CITY OF ALBUQUERQUE

February 19, 2014

**Re: Drainage Master Plan and Grading Plan for Del Webb Phase 1 and 2
Engineer's Stamp Date 2-7-14 (H09D017C)**

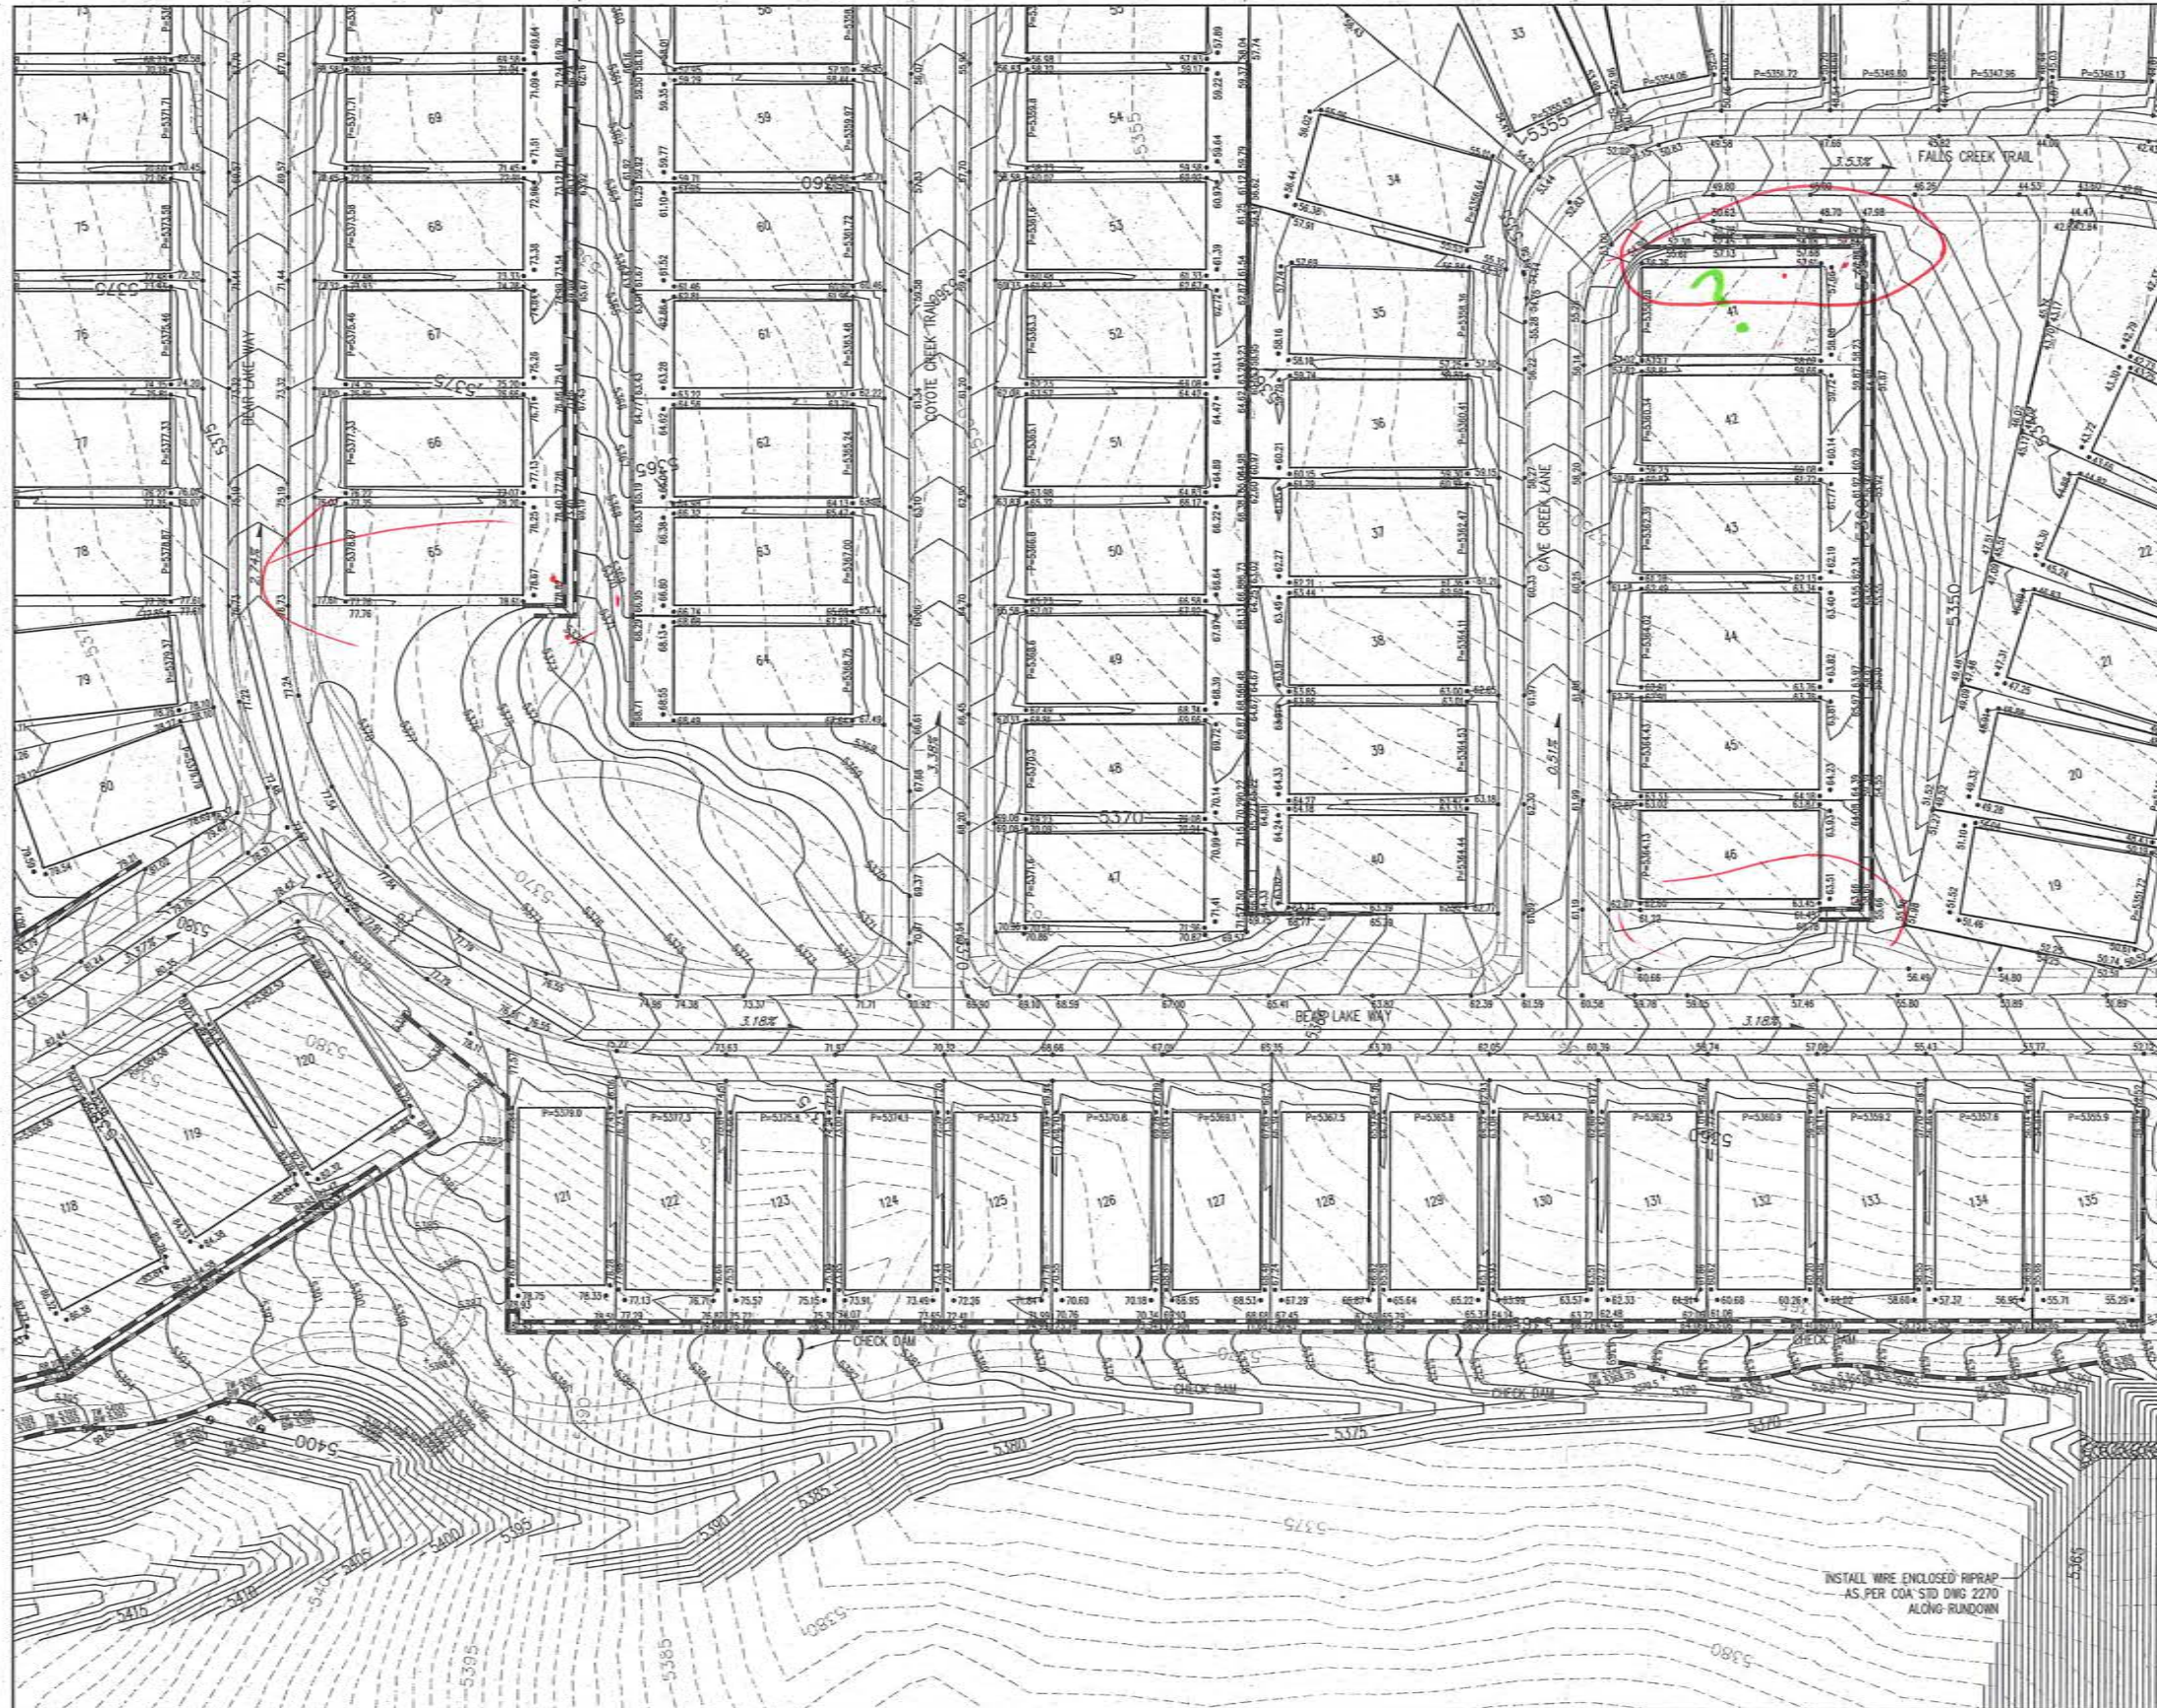
3. Provide rip-rap in the outfall area of Temporary Pond #2 to prevent sediment from entering the street.
4. On Sheet 6, 7 and 8, should a clear area be provided between the wall and the trail?

DESIGN REVIEW COMMITTEE	CITY ENGINEER APPROVAL	LAST DESIGN UPDATE	MO./DAY/YR.	MO./DAY/YR.	
CITY PROJECT NO.	ZONE MAP NO.	SHEET	8	OF	8

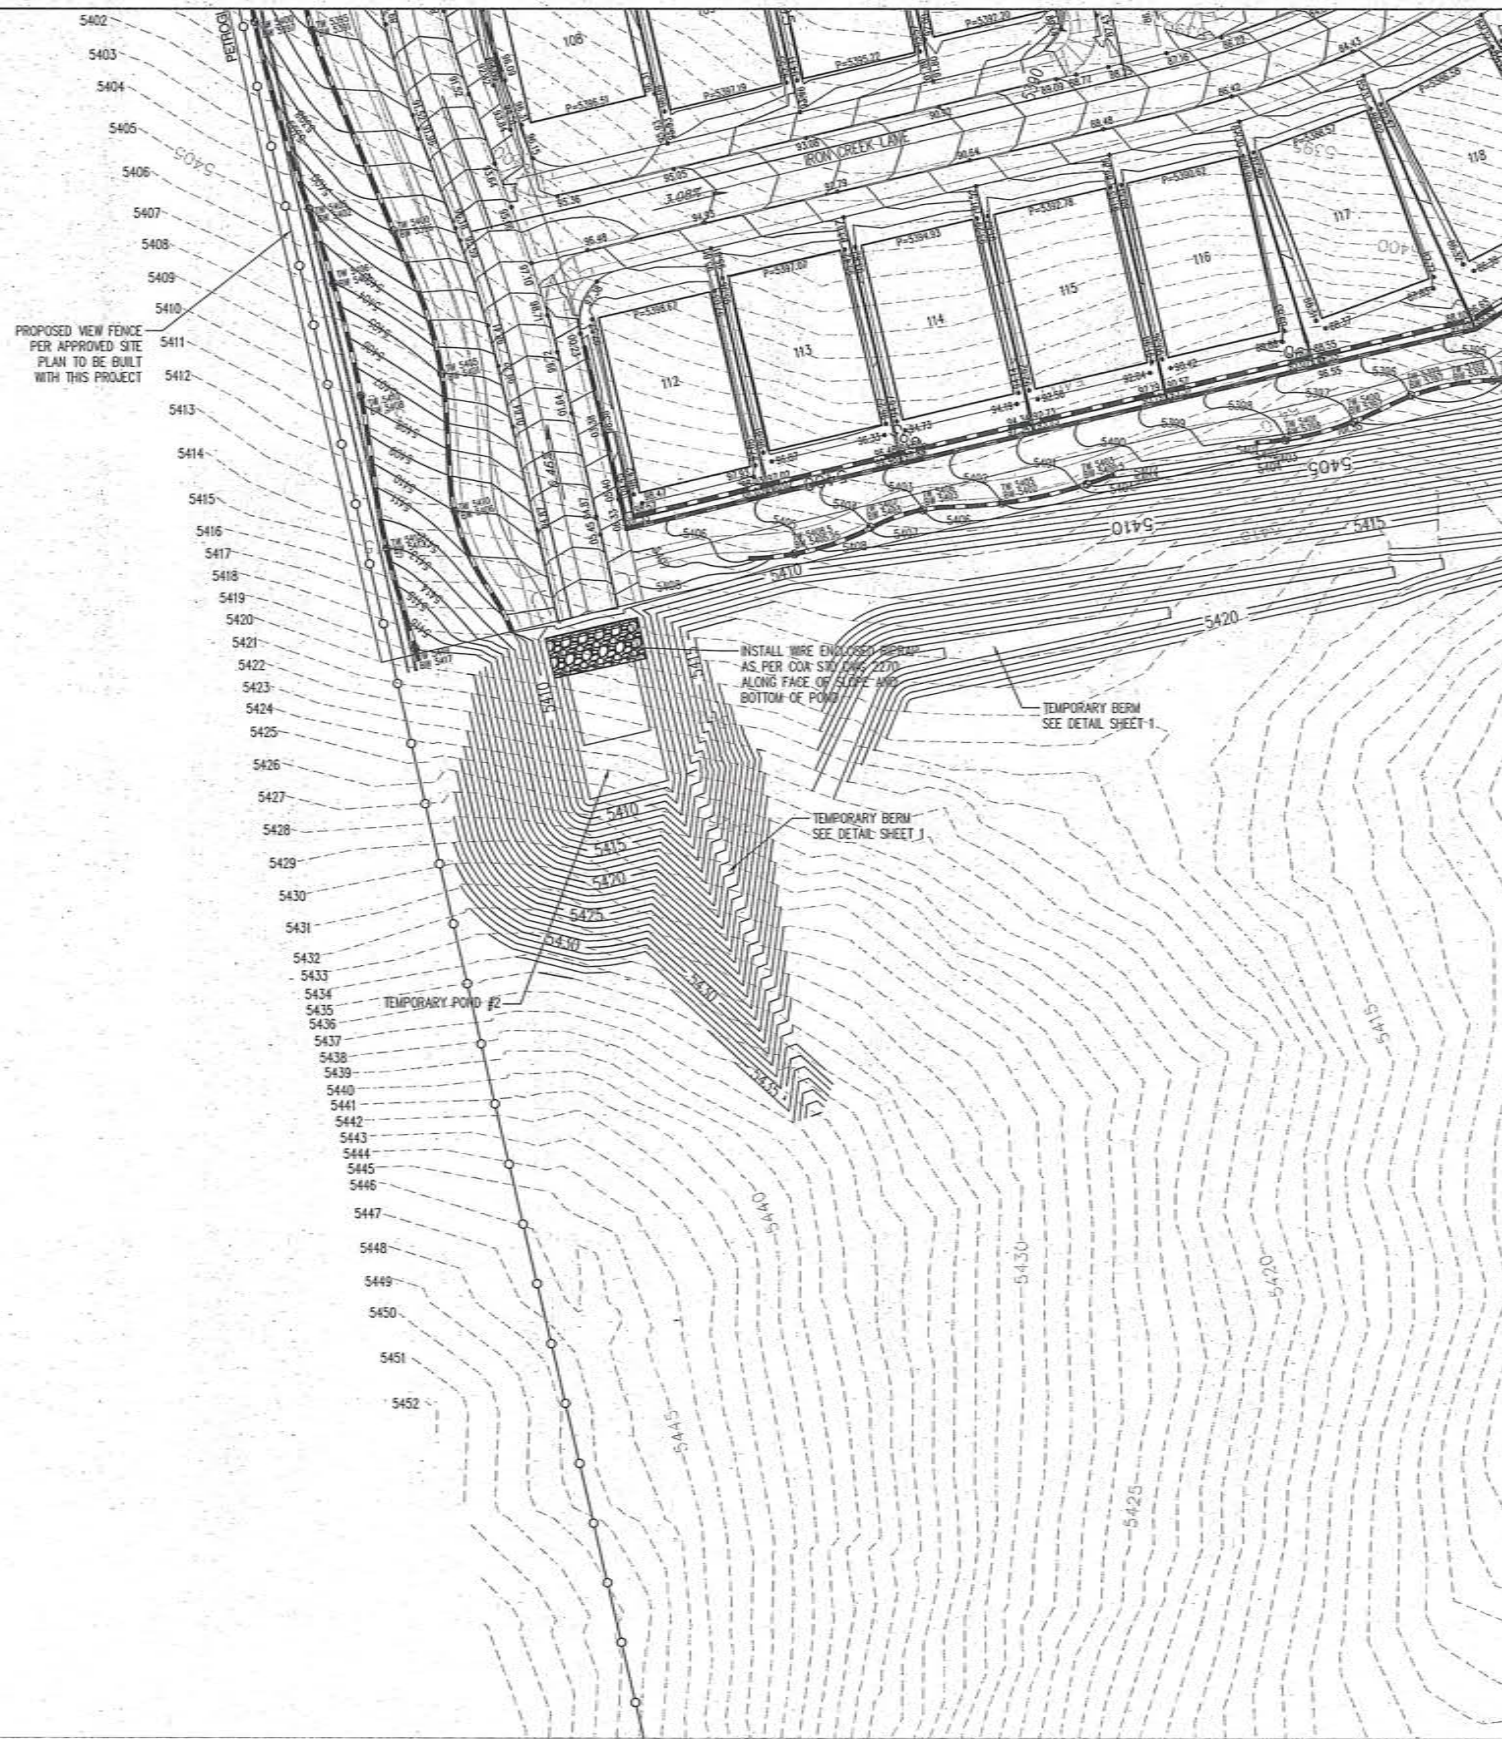
5. Why does the retaining wall have a break in it on Sheet 8? Grades in this area appear to be steeper than 3:1.
6. On Lot 112, what does the symbol represent between the 00.40 and 98.42 grade?

CITY PROJECT NO. _____ ZONE MAP NO. _____ SHEET 3 OF 8

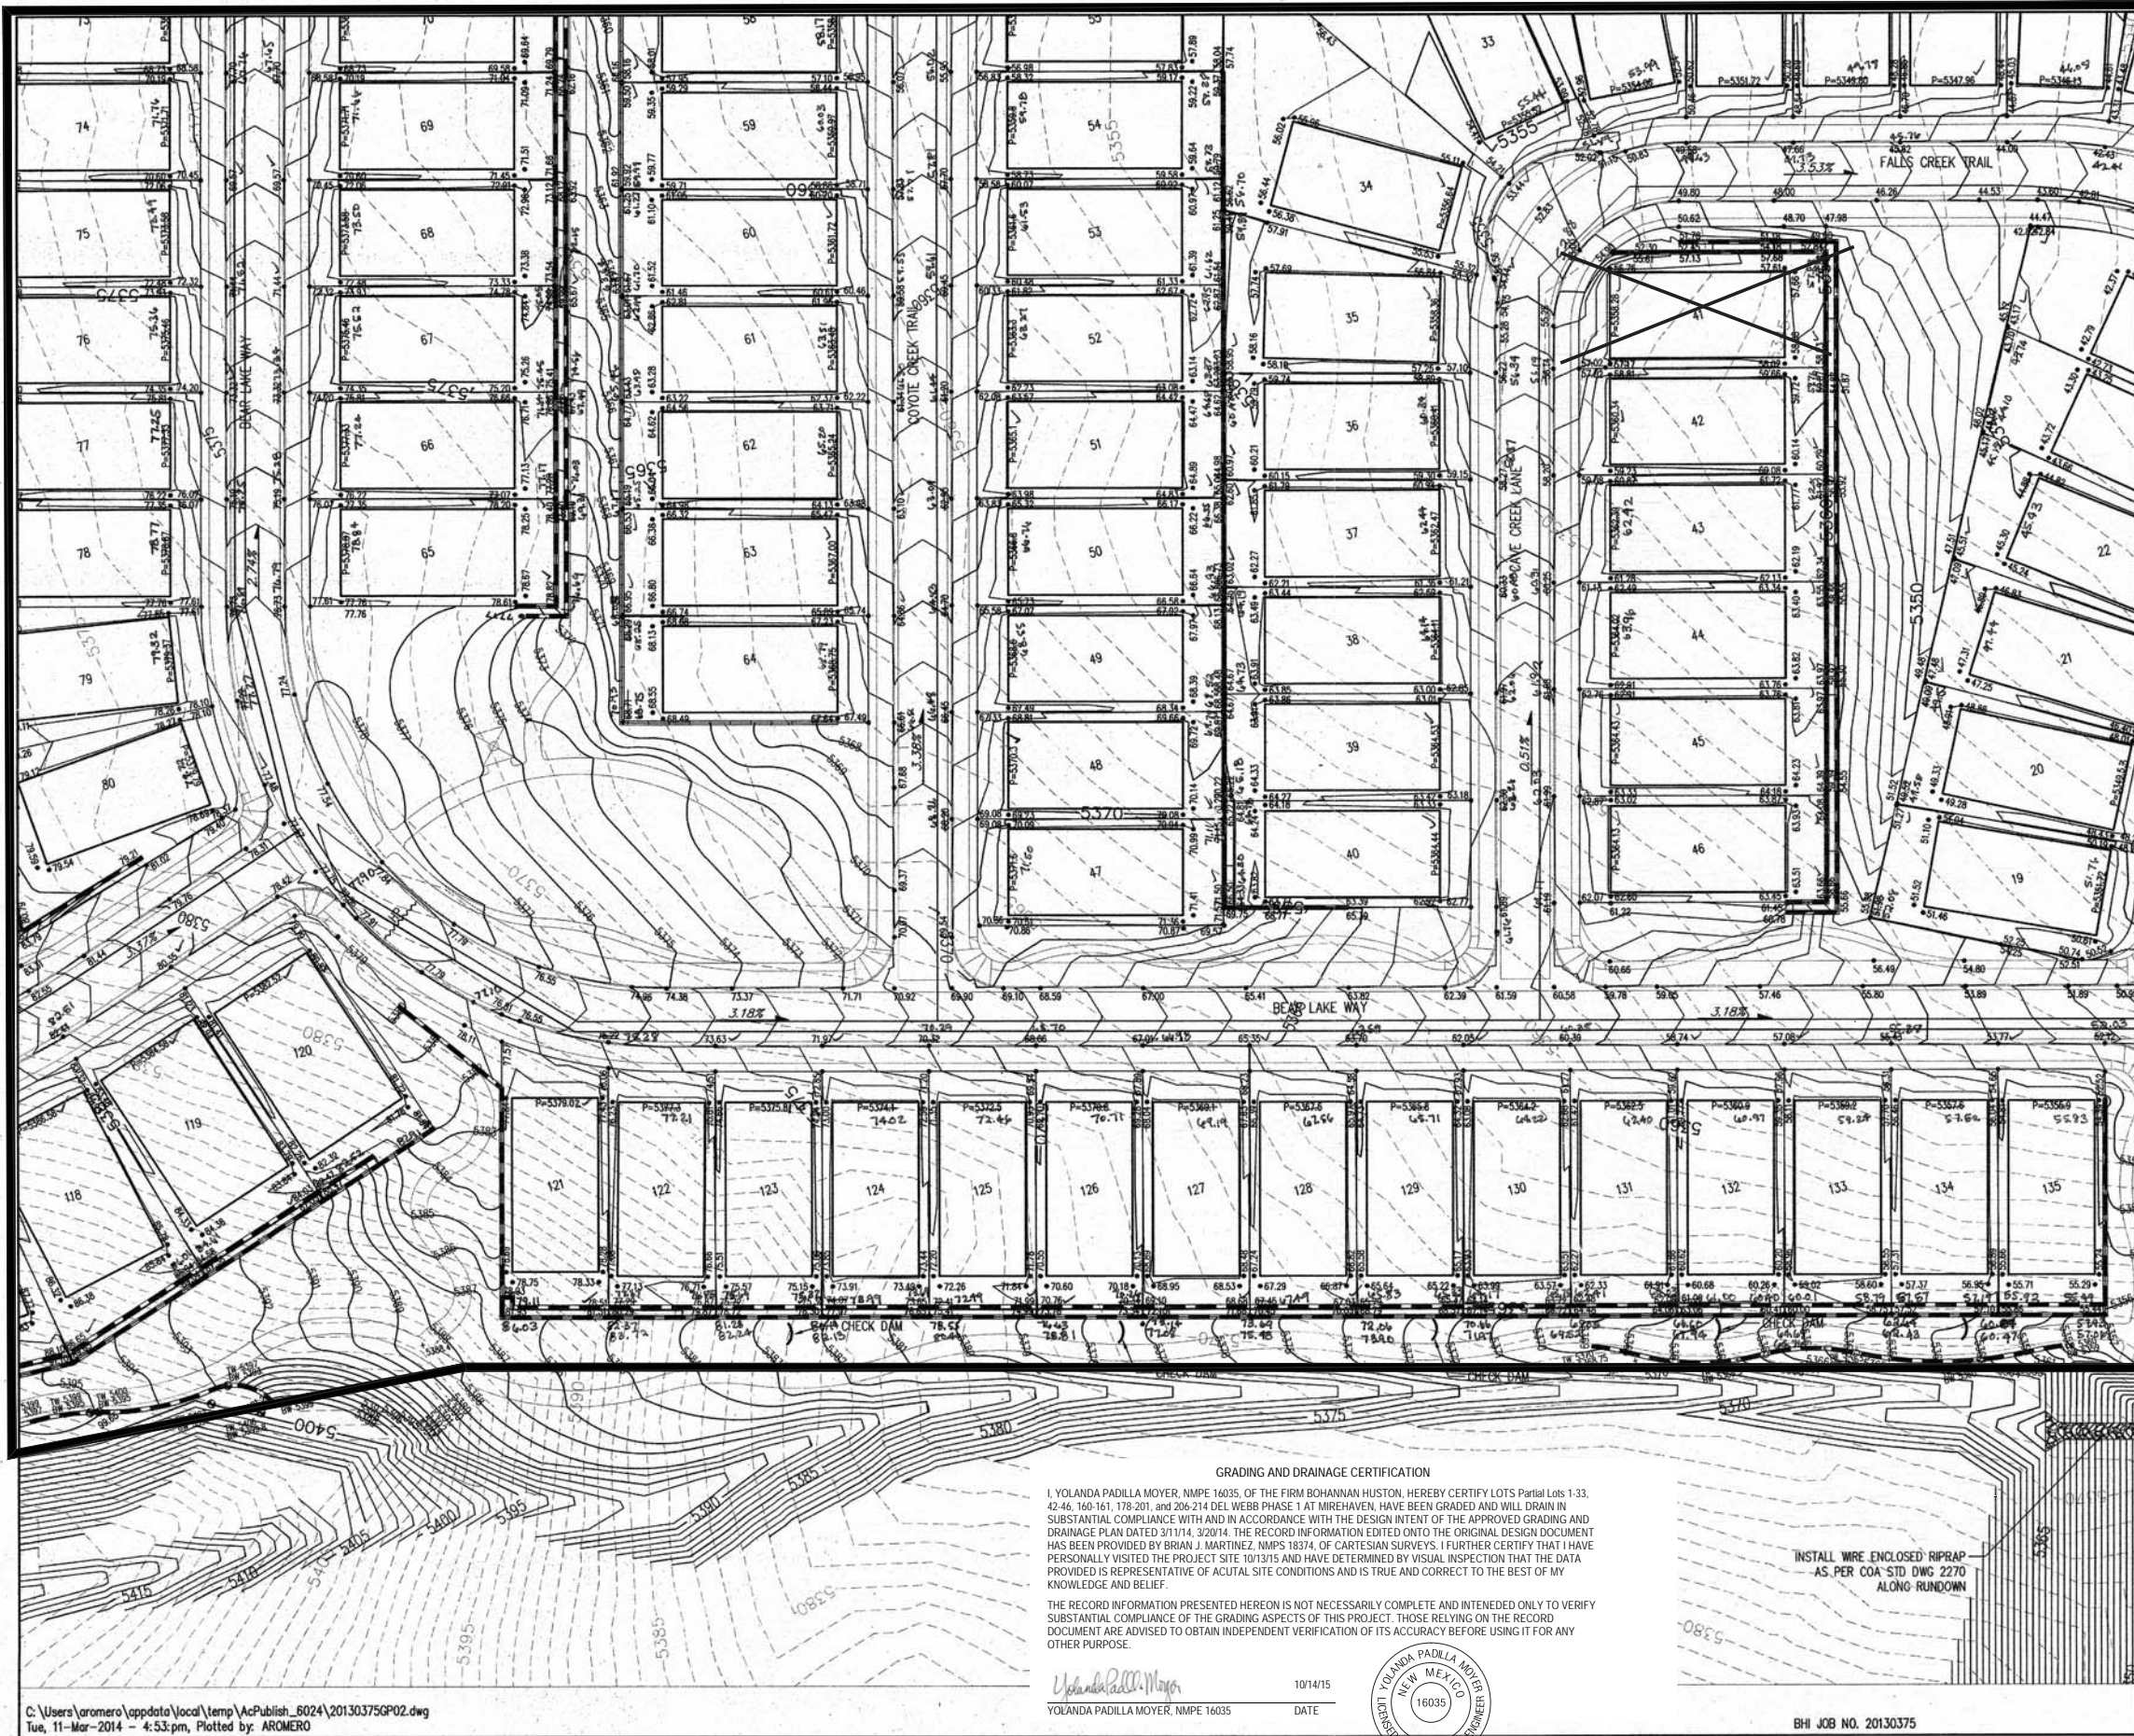
13. The side slopes on the Temporary Pond in Coyote Creek Trail should be 3:1 or flatter.
14. Provide the line-type in the legend for the lines on Sheet 3 that appear to be walls. Similar comment for Lot 148 and on other sheets.

15. Call out the inlet or similar on the storm drain on Sheet 3.
16. The trail is proposed in the water harvesting area on Sheet 3.
17. Label the invert for Outfall A at the channel.
